15th February 2021

Application No: A/193/20/PL
Site Address: Ham Manor Cottage Ham Manor Way Angmering BN16 4JQ
Description of works: Erection of a 1 No. 3 bedroom chalet bungalow & detached garage. This site is in CiL Zone 3 and is CIL Liable as dwelling.

Thank you for your internet representation made on 14th February 2021 which has been recorded as an objection with the comments as follows:

Proposed Street Scene (Scale 1:200)

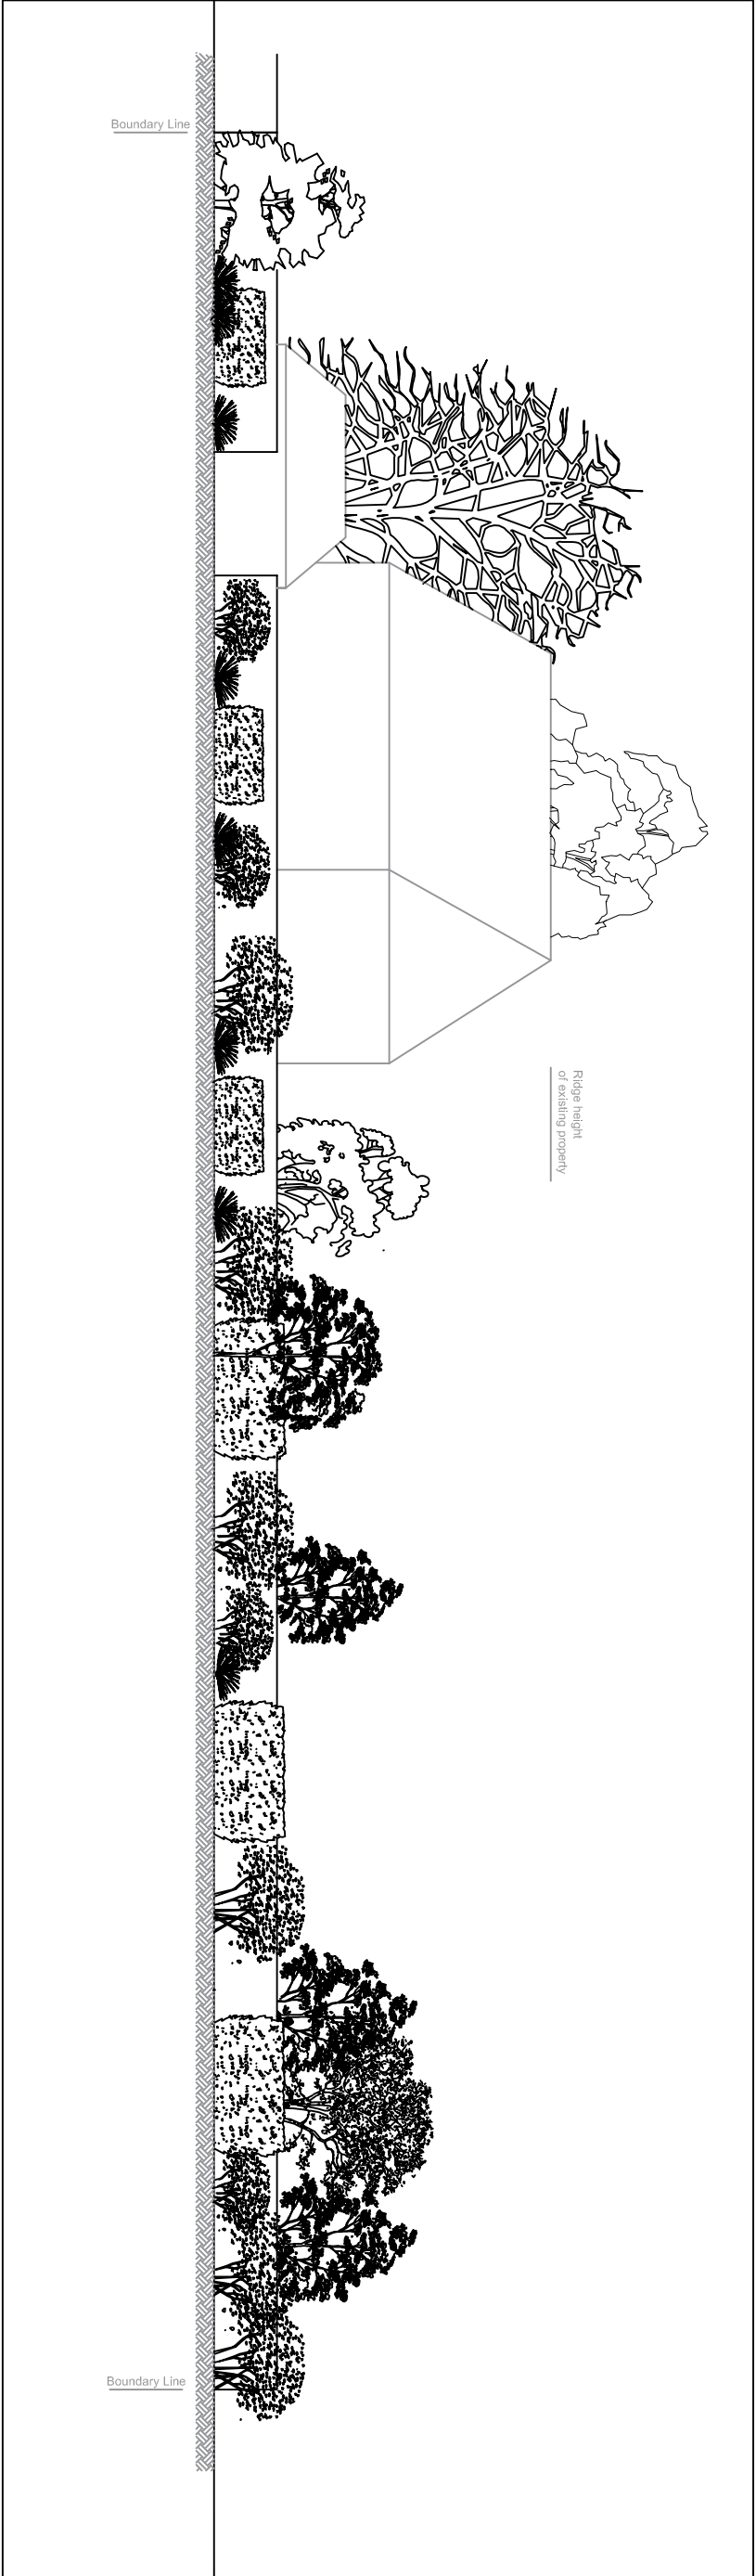
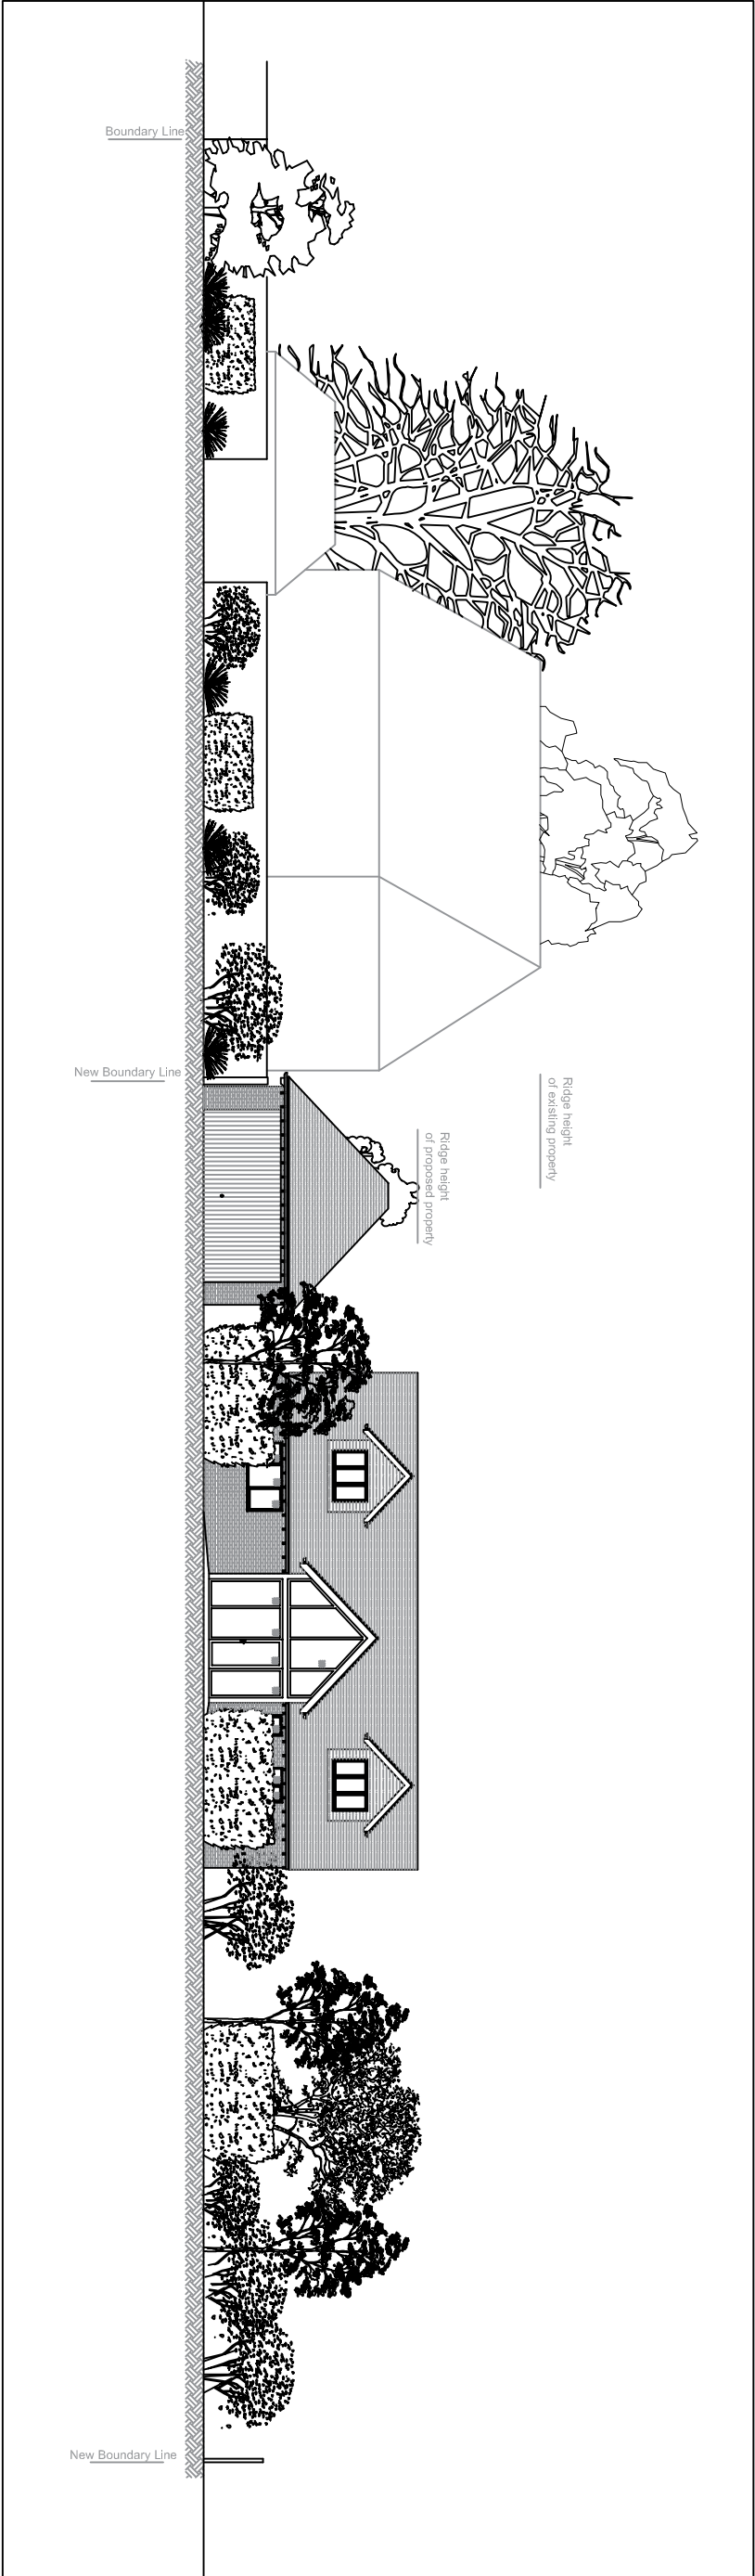
The proposed property is positioned well forward of the historic build line which will have a large impact on the character of the Ham Manor Estate. All houses without any exception are built with a large frontage especially along Ham Manor Way. This development will change the look of the well-established street scene and should be resisted in changing this characteristic to allow a garden plot development on a too small and awkward shaped plot.

Revision:	A	Dec 2020	Dimension added
address	Ham Manor Cottage, Ham Manor Way, Worthing, West Sussex		
project	Proposed construction of 3 bedroom detached property with detached double garage		
title	Proposed Block Plan		
scale	date	dwg no.	revision
1:200 on A4		2020.275.02	A

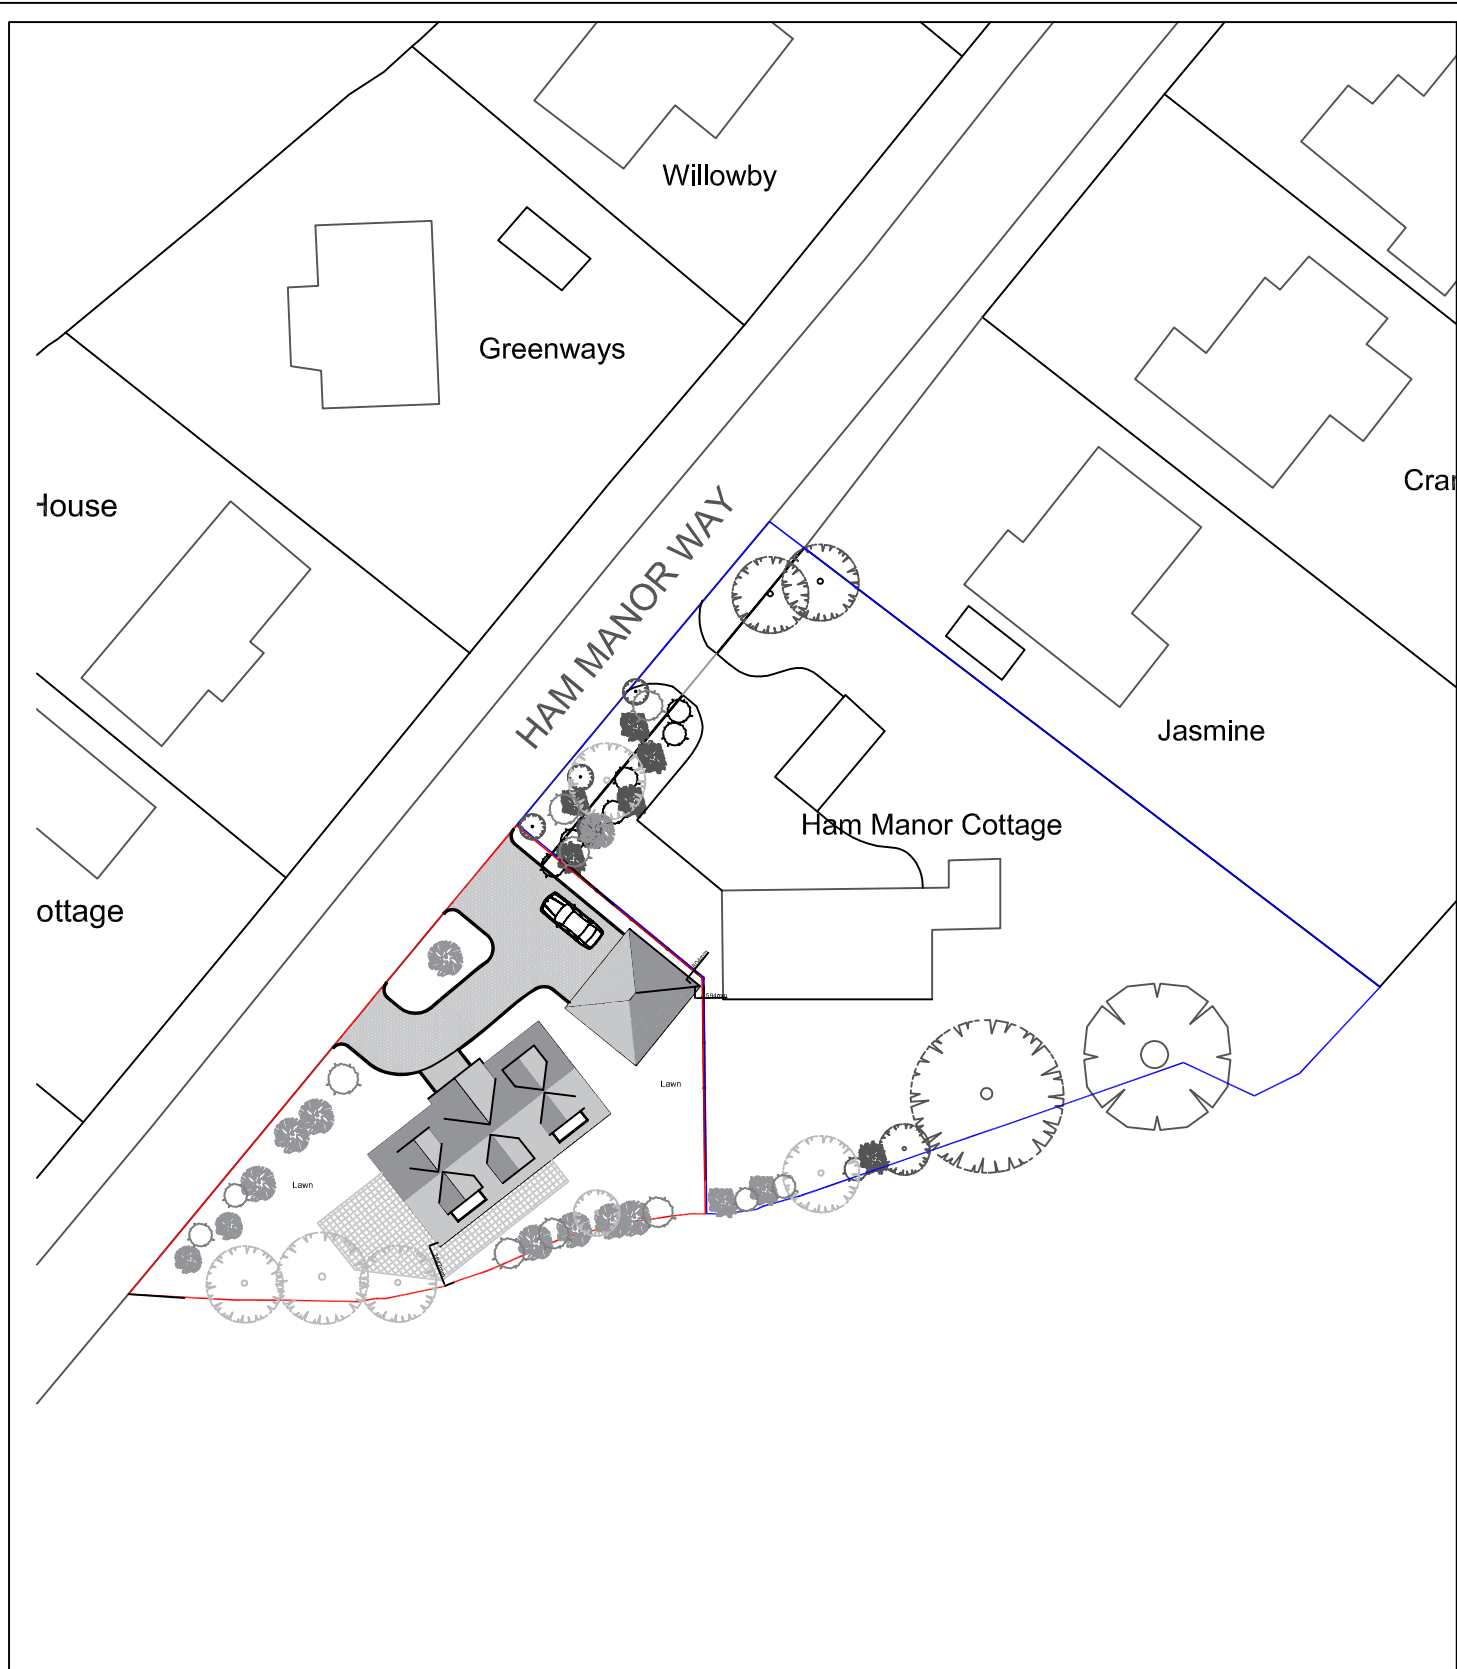
6.13 "away from the the front boundary and in line with the neighbouring dwelling to north" it is not in line and is over the build line.

proposal located well forward of the build line.
